Ribble Valley Borough Council
Housing & Development Control

Your ref: 3/2023/0452
Our ref: D3.2023.0452
Date: 24th January 2024

Application no: **3/2023/0452**

Proposal: **Proposed construction of single storey pavilion restaurant. Change of use of grazing land to hotel grounds and to facilitate new vehicular access, parking and landscaping.**

Drawing title
 TREE REMOVAL PLAN

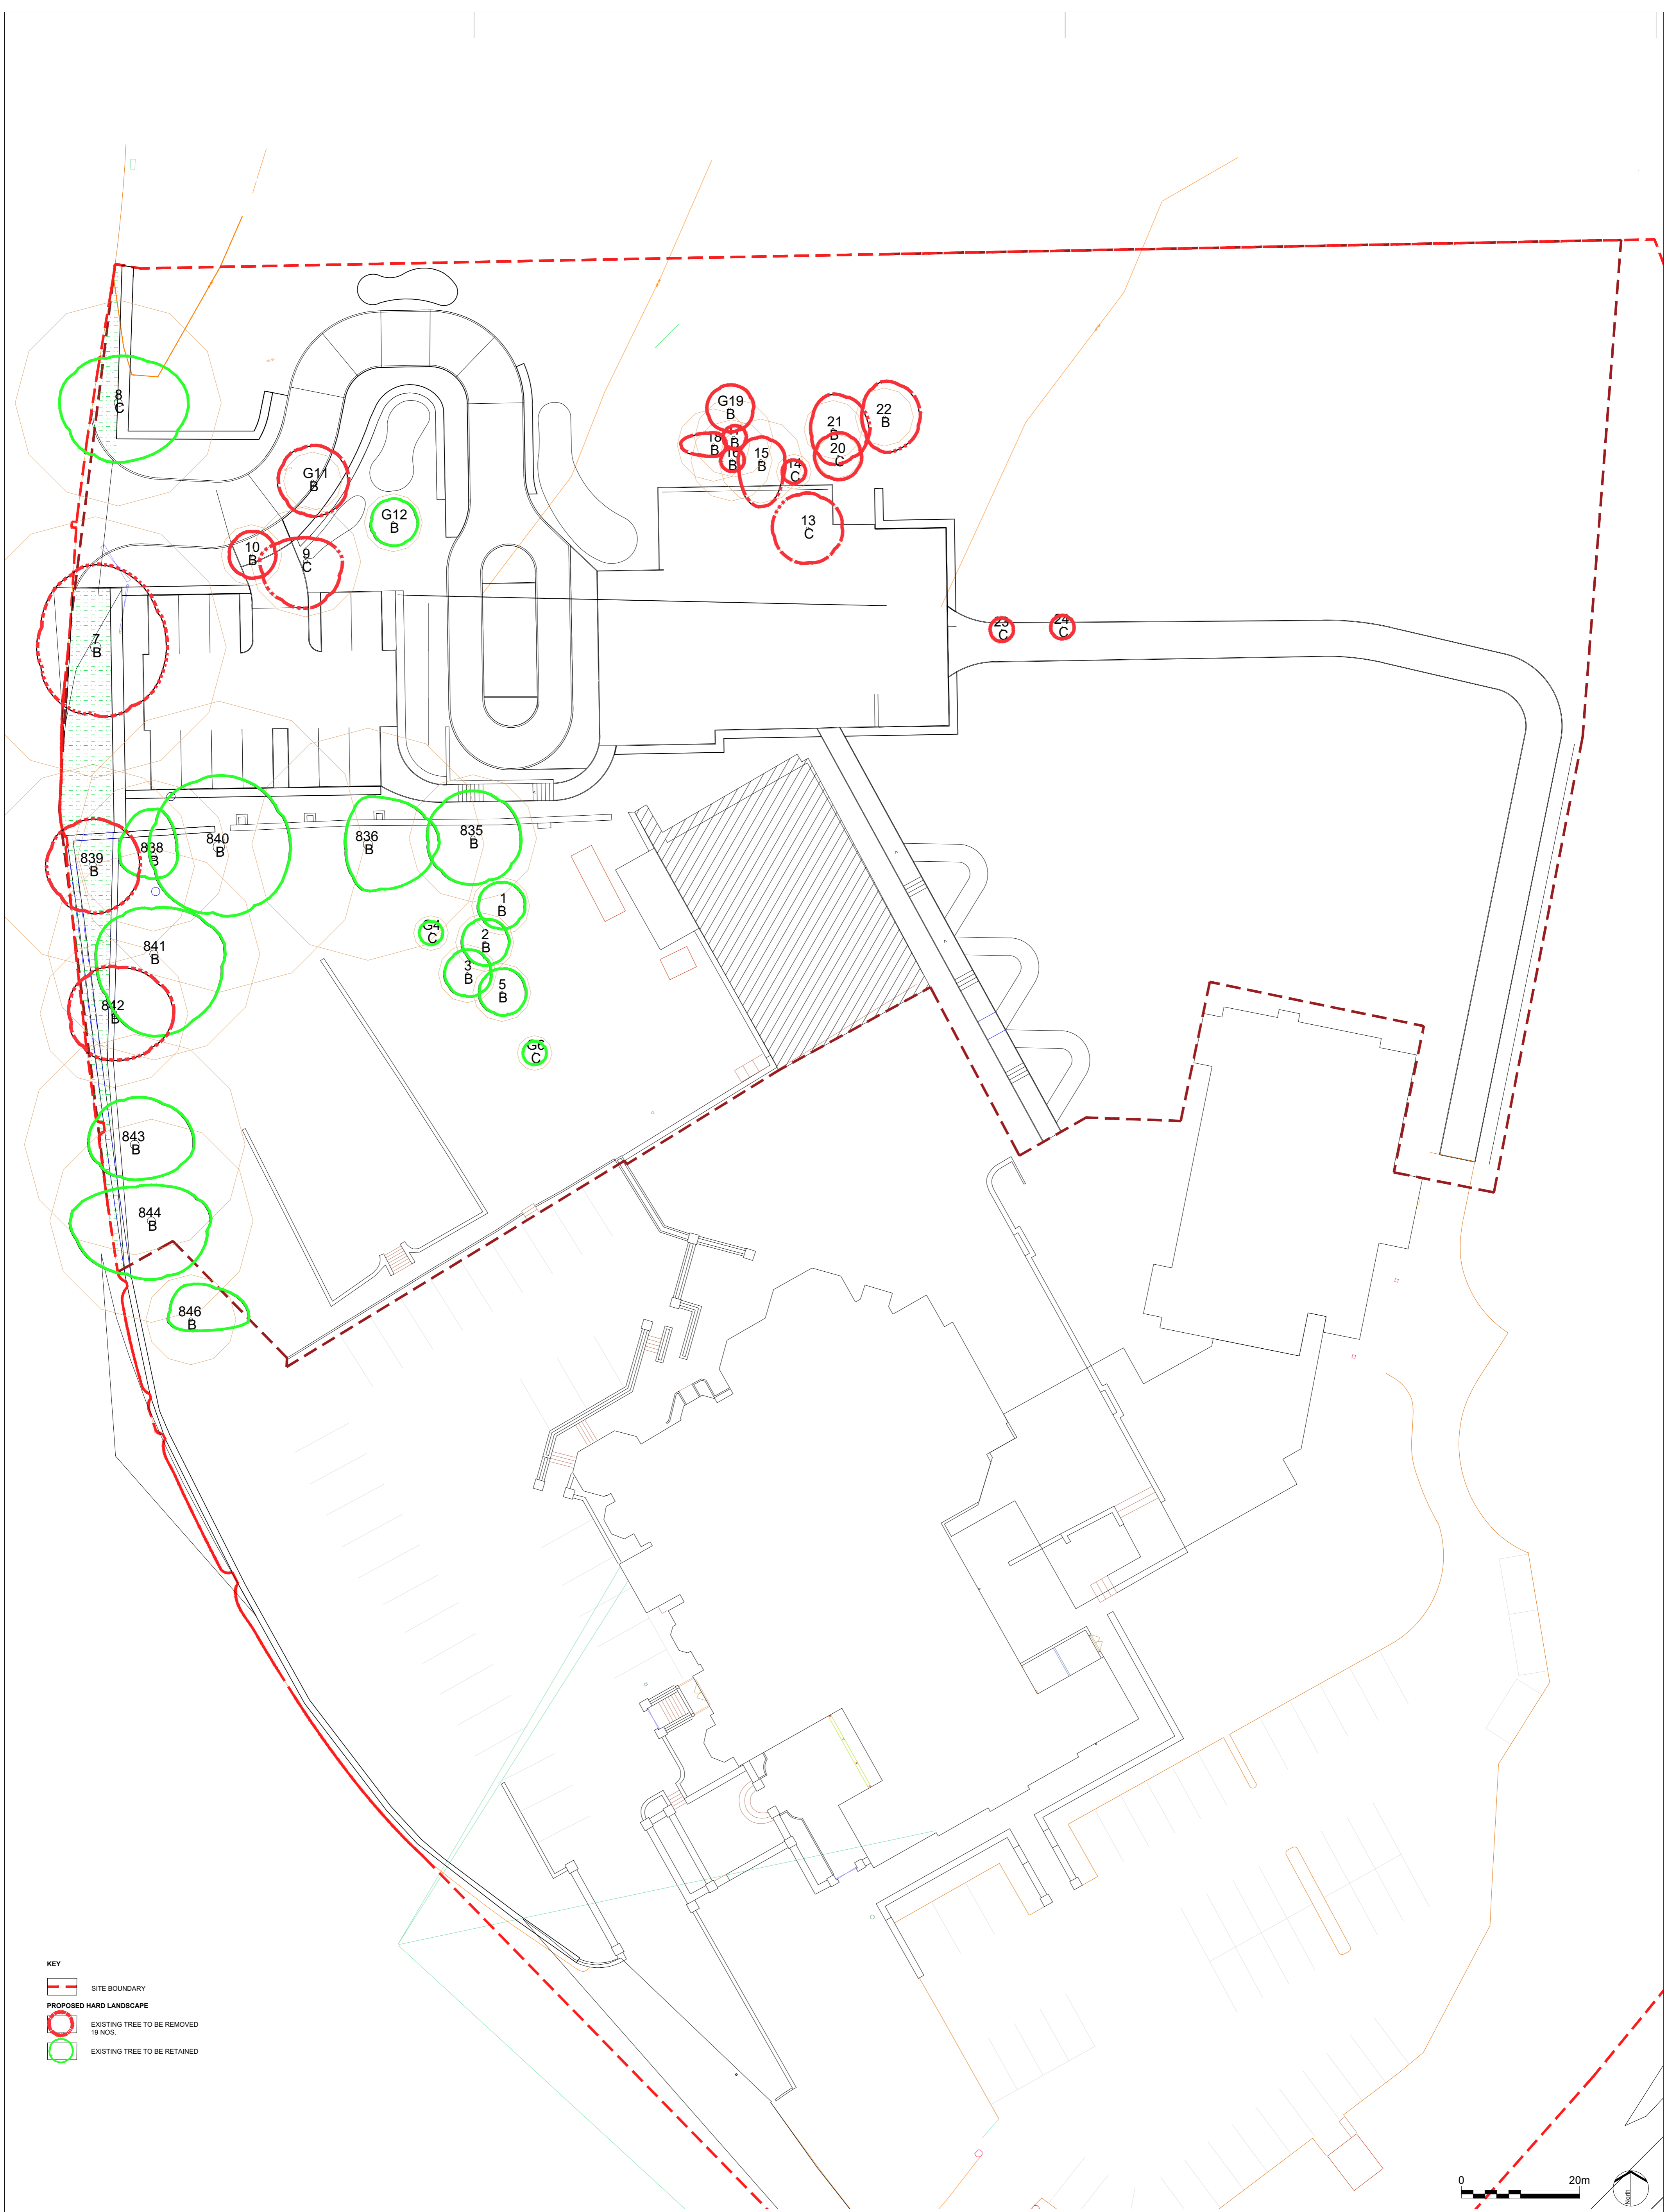
The Agent has provided Vectos drawing number VN222320-D102 Rev B titled "Site Access Arrangements" which shows that the access can provide adequate visibility. The access can achieve the required visibility to the north by removing tree 7B, as shown on 3D Reid drawing number 2261-EXA-XX-XX-DR-L-00150 Rev P03 titled "Tree Removal Plan" and by setting back the retaining wall feature from the adopted highway.

The LHA have no objection to the removal of the tree or setting back the retaining wall further into the site for a short distance but will condition that a landscaping plan is submitted prior to commencement. This is to ensure that suitable vegetation such as slow growing shrubs are planted in between the adopted highway and the retaining wall.

4. No part of the development hereby permitted shall be occupied until such time as vehicular visibility splays of 2.4 metres by 50 metres to the north and 2.4 metres by 51 metres to the south have been provided at the site access. These shall thereafter be permanently maintained with nothing within those splays higher than 1 metres above the level of the adjacent footway/verge/highway.

5. No development shall take place until details of a landscaping and maintenance scheme of the land within the approved visibility splays have been submitted to, and approved in writing by, the local planning authority in consultation with the highway authority.
